1041 PERMIT APPLICATION SUBMITTAL
FOR
TOWN OF RAMAH WASTEWATER SYSTEM
SEWER LIFT STATION
&
WASTEWATER TREATMENT PLANT

1041 Documents Related to 3.201 (Items 1 - 4)_v1.pdf Markup Summary 8-30-2022

EXHIBIT BB – NEIGHBORING WATER SYSTEMS VICINITY MAP

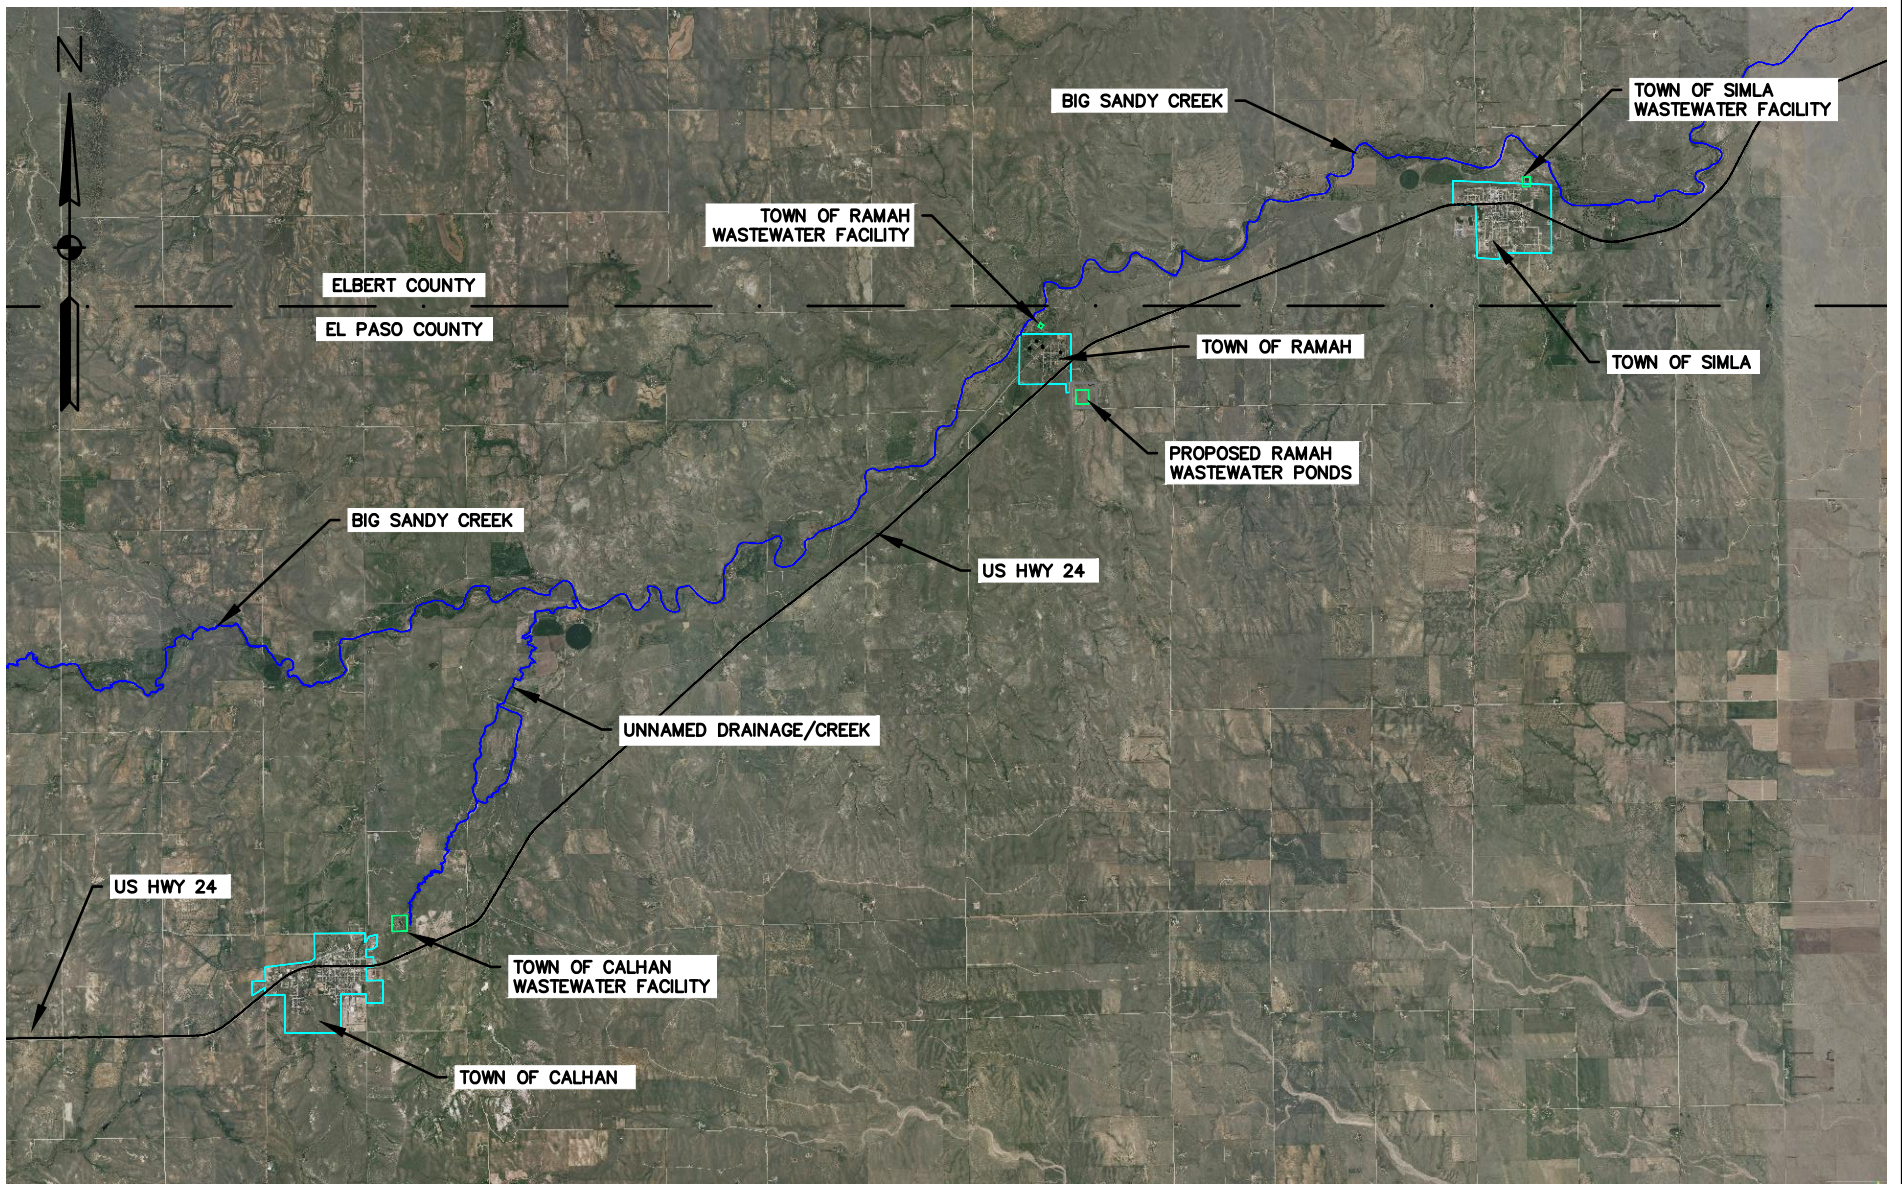
provide map exhibit within answer
